Subject: Shoreline Exemption Permit, Pump Station 15 – 4765 Forest Ave. SE.

This is a written response to the review comments provided by the Community Planning and Development Department regarding the application for the Shoreline Exemption Permit, SHL23-012, for Pump Station 15 located at 4765 Forest Ave. SE.

INSTRUMENTATION
PUMP STATION 15 - PLAN

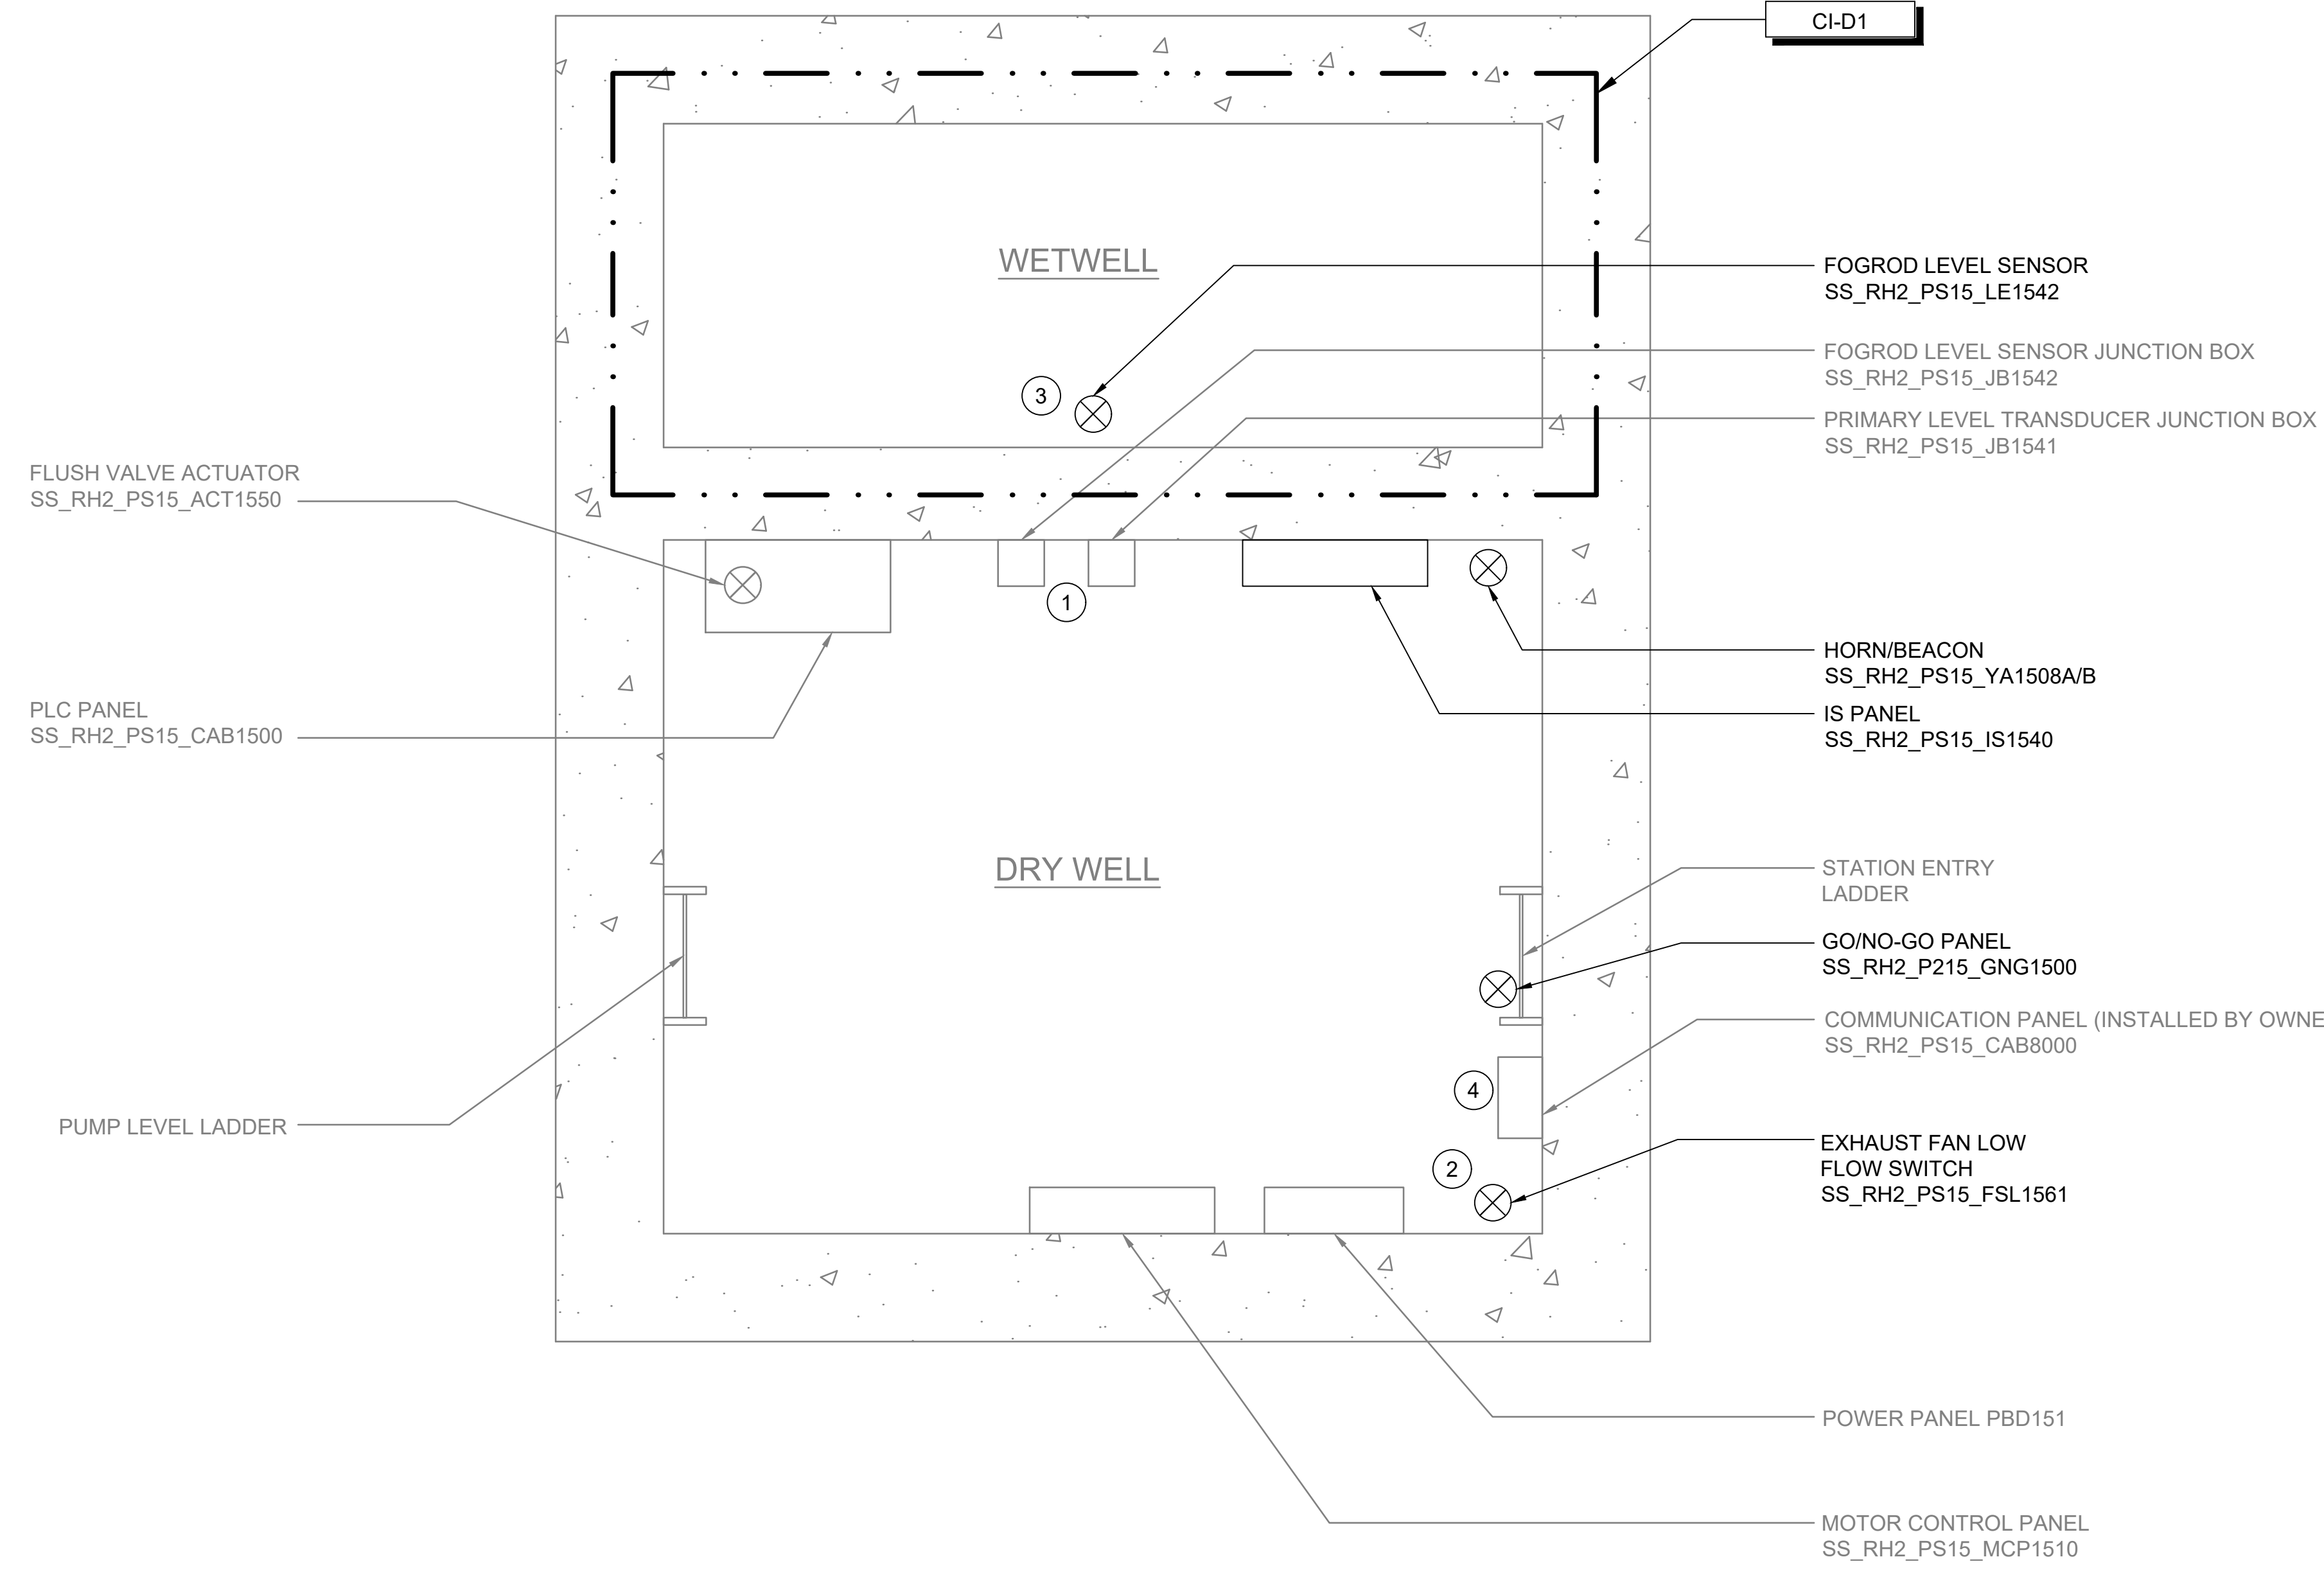
- a. Provide address of all pump stations on plans

**Response:** *The address for the pump station has been added to Development Plan, Instrumentation Drawing page 1. The address was also included in the aerial photo of the pump station.*
